CITY OF ALBUQUERQUE

January 6, 2022

RE: 2710 Sheridan 2710 Sheridan St. NW Grading and Drainage Plan Engineer's Stamp Date: 12/30/2021 Hydrology File: C19D011D6

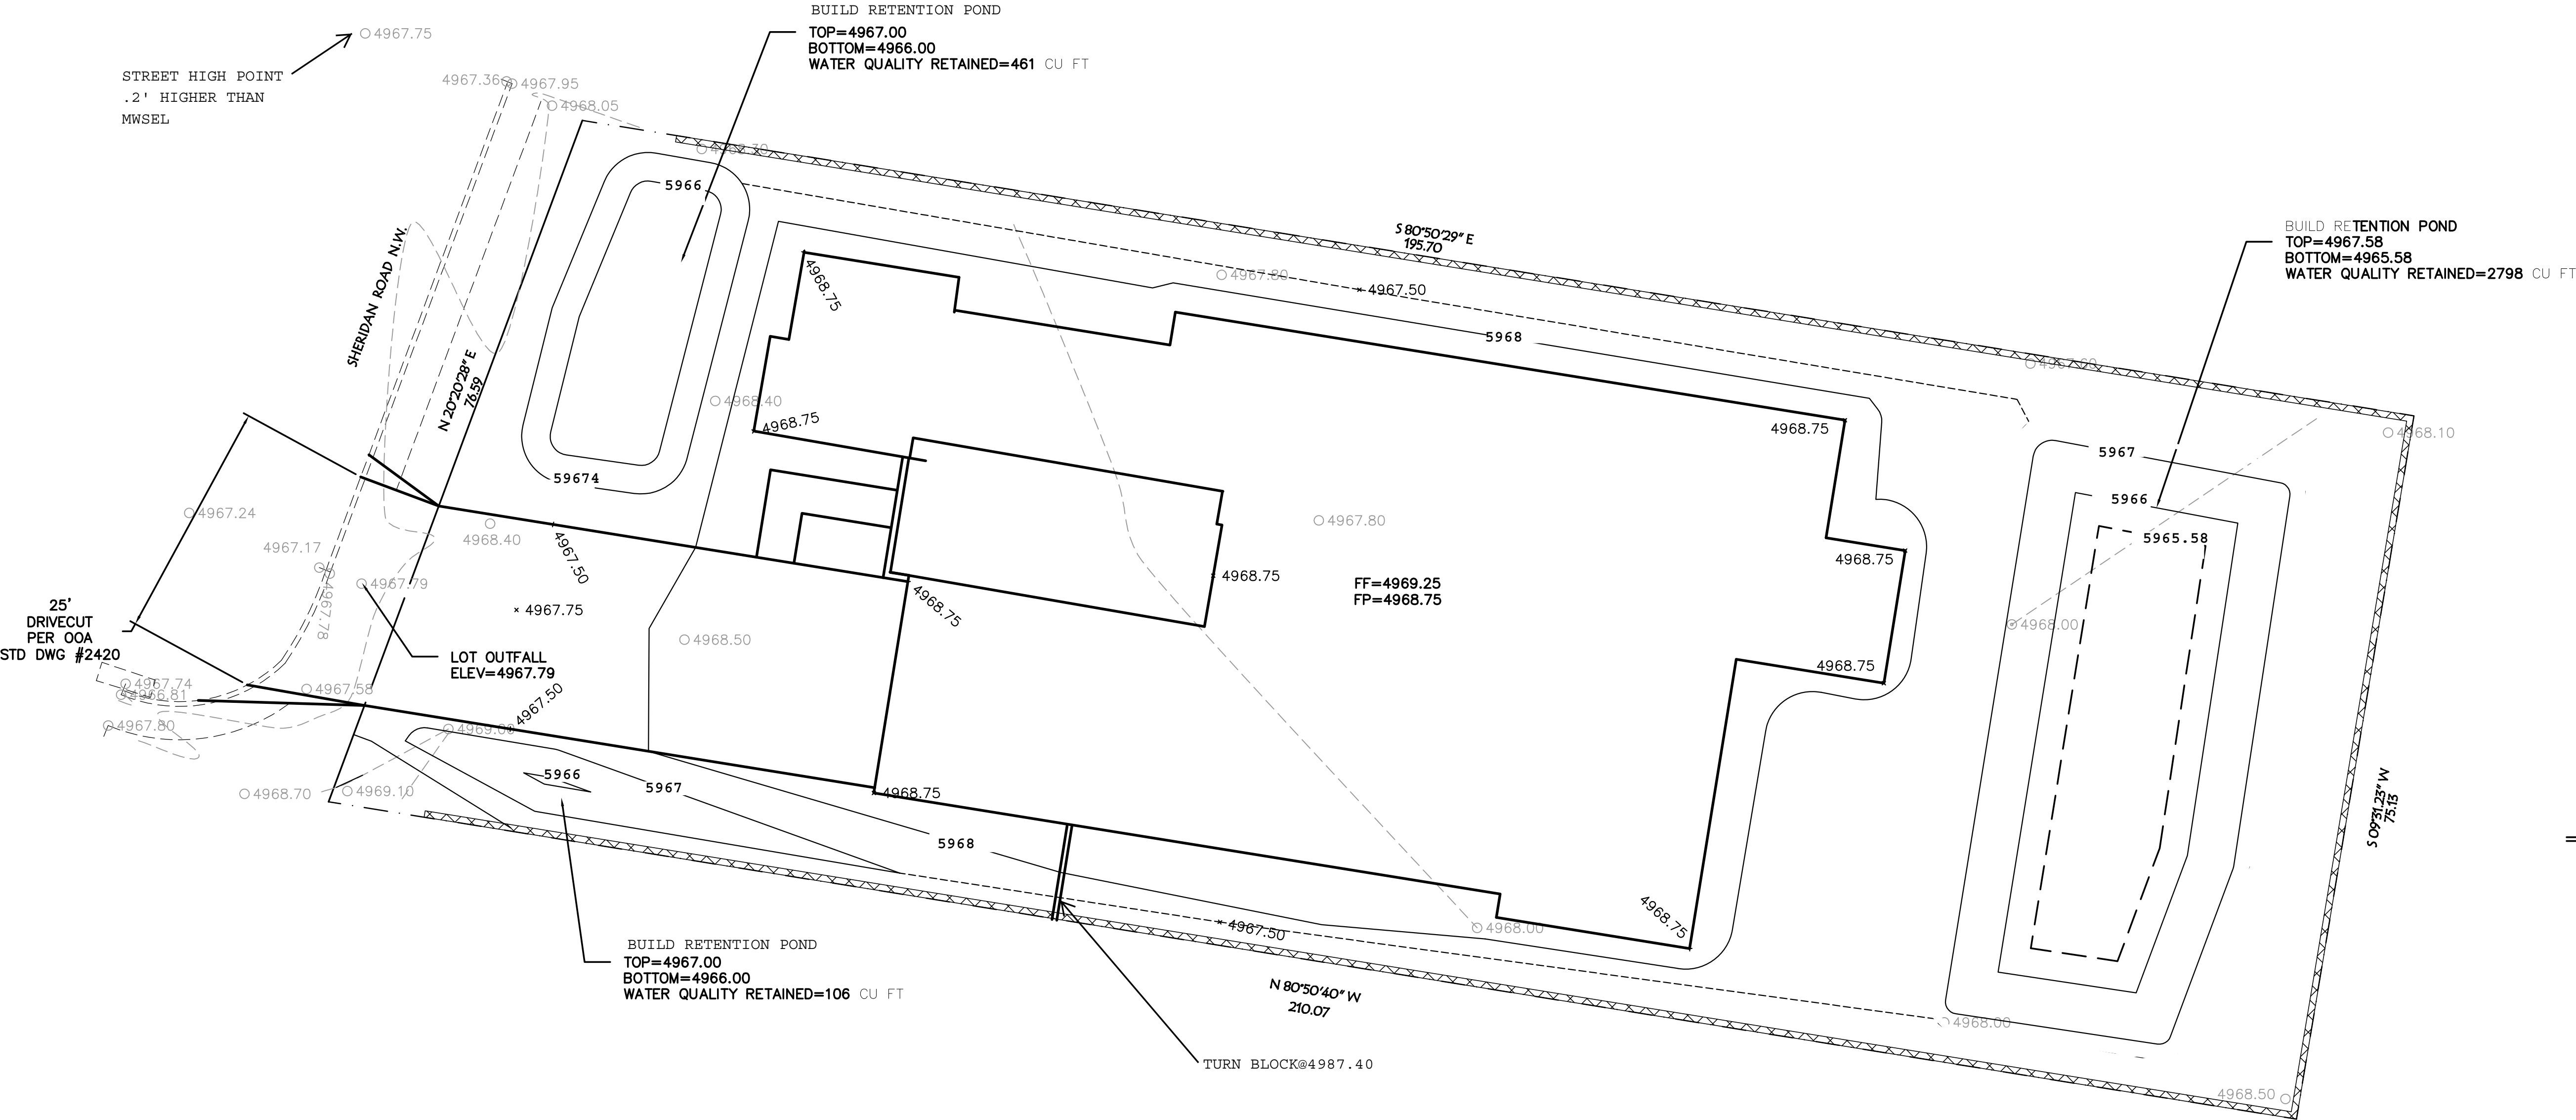
- 1. Please include the 100-yr 10-day storm calculations.
 - a. If the site is following the flat grading scheme ensure it meets all criteria. I think much is met however see following.

- i. Show how high point of internal streets is 4 inches higher than 100-yr 10day storm. (not sure this is the case for this situation.)
 - ii. Provide retention for 100-yr 10-day storm event not the 24-hr.

- iii. Finished pad elevation shall be a minimum of 1 ft above the water elevation of the 100-yr 10-day storm event.
- 2. The shown wall is called a CMU screen wall. This will need to ensure a portion is not screen and retains flow from entering other adjacent properties per DPM requirements. Provide these water elevations with section (noted below)

- 3. Please include reference to appropriate datum.
- 4. Please ensure flow is not obstructed between the front and back yard for water equalization per DPM. I see a wall proposed on the south end potentially blocking any water from transferring/equalizing.

- b. Will there be a cut out and swale at the shown flowline (intermediate contour 4967.50)?
- PO Box 1293
 5. Please show proposed contour elevations including the pond contours. Provide spot elevations at the driveway and ensure that the entrance does meet the DPM flat grading scheme to retain the flow rather than discharge as shown. Again, this is a little different than typical flat grading scheme as there is curb and gutter and would allow flow into the street.

WALL DETAILS AT ALL PROPERTY BOUNDARIES

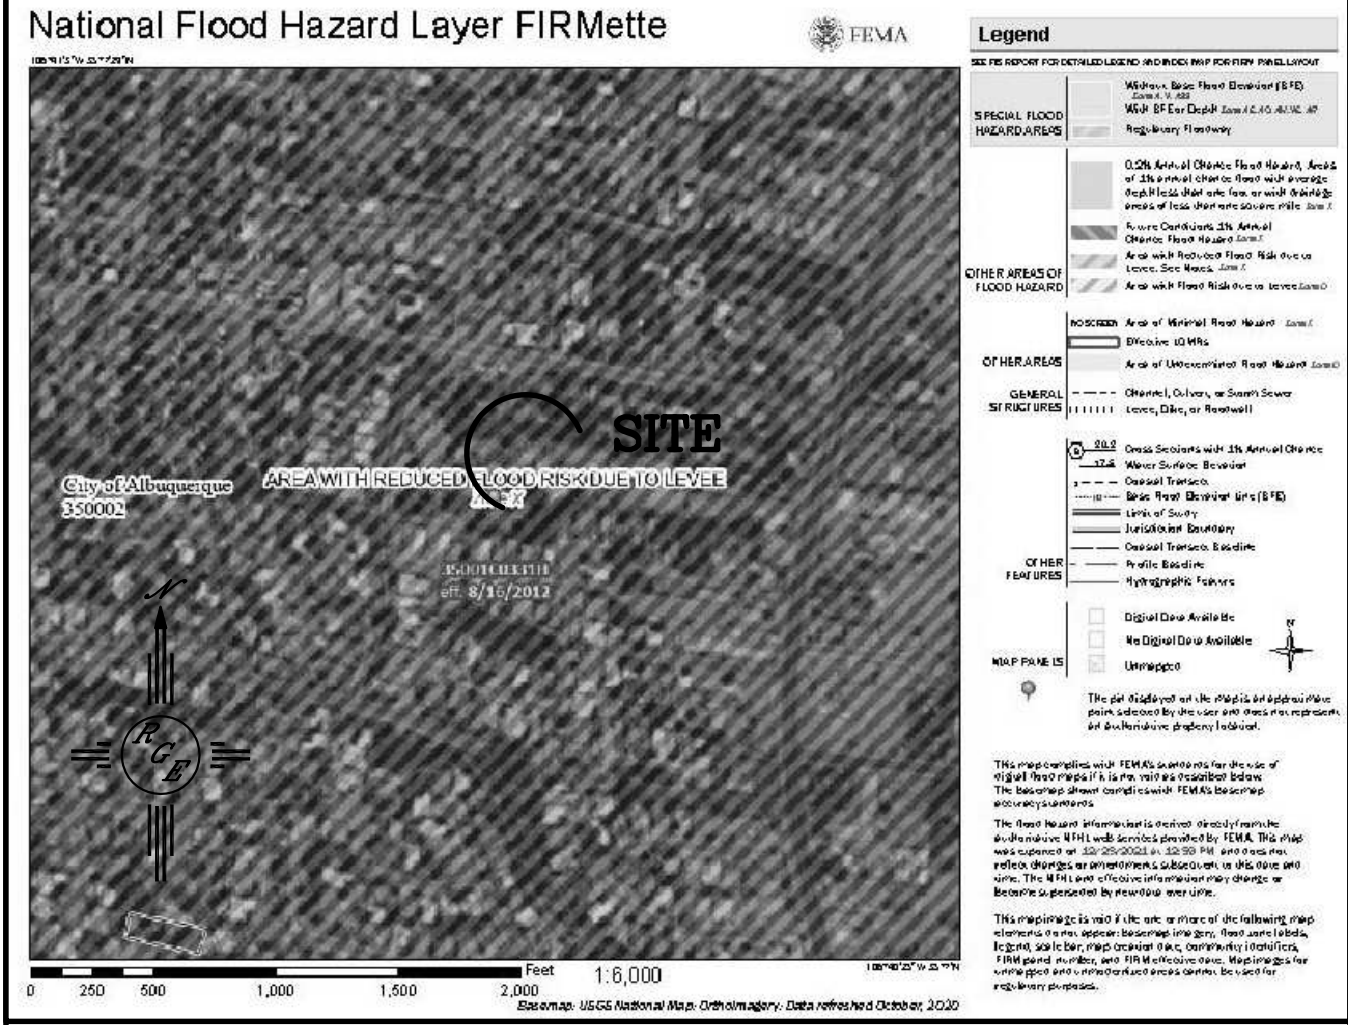
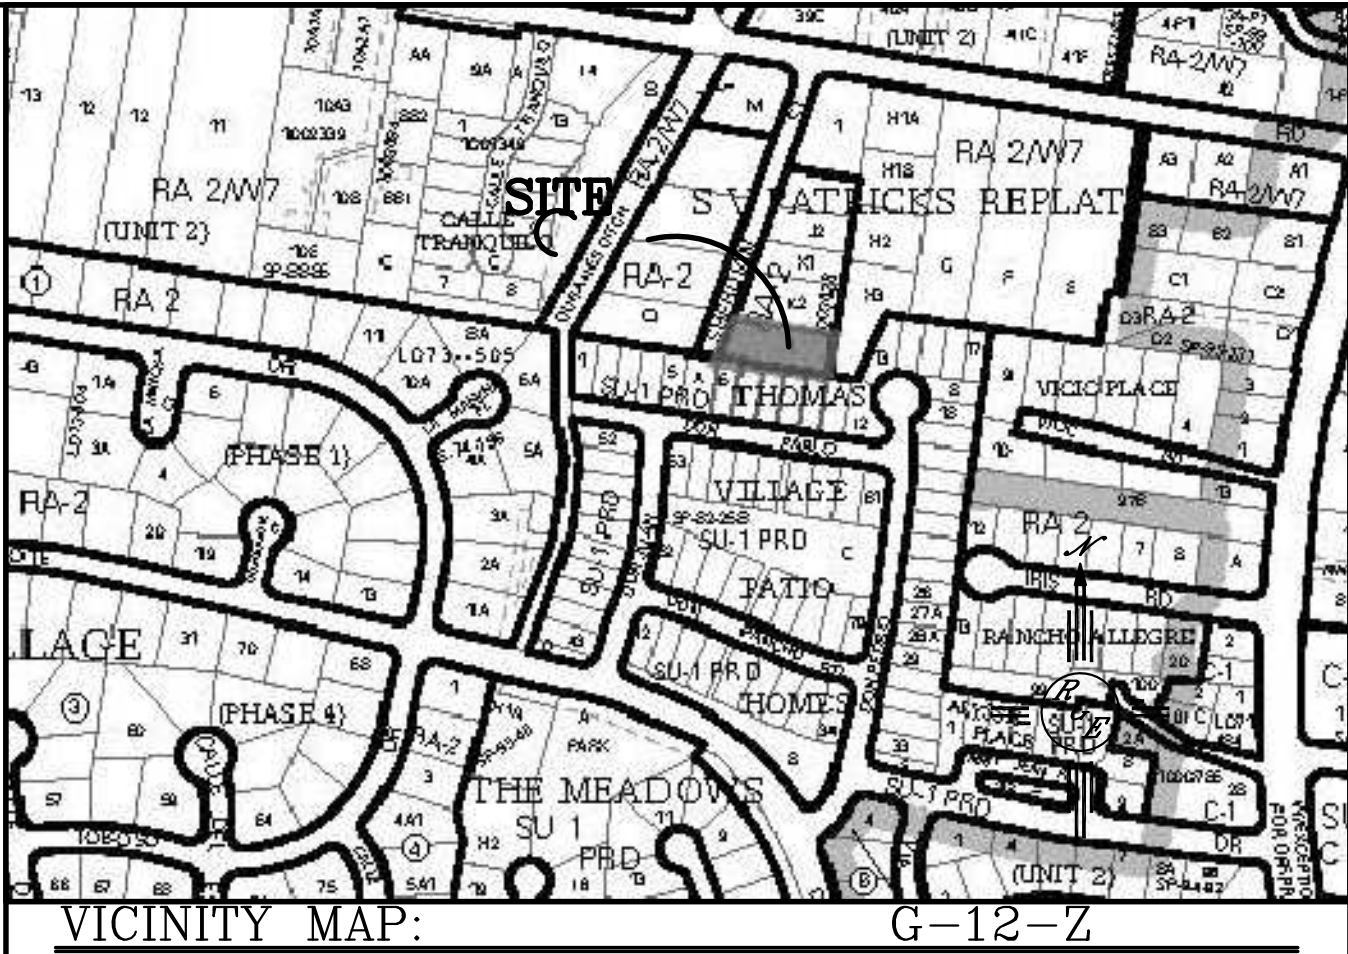
- 7. Please note none of the ponds are water quality ponds. Please provide proper naming.
- 8. Provide a section of the wall simply showing that any footing will remain within the property line. Call out the footing, and property line on the section as well as show the water elevation of the 100-yr 10-day storm.
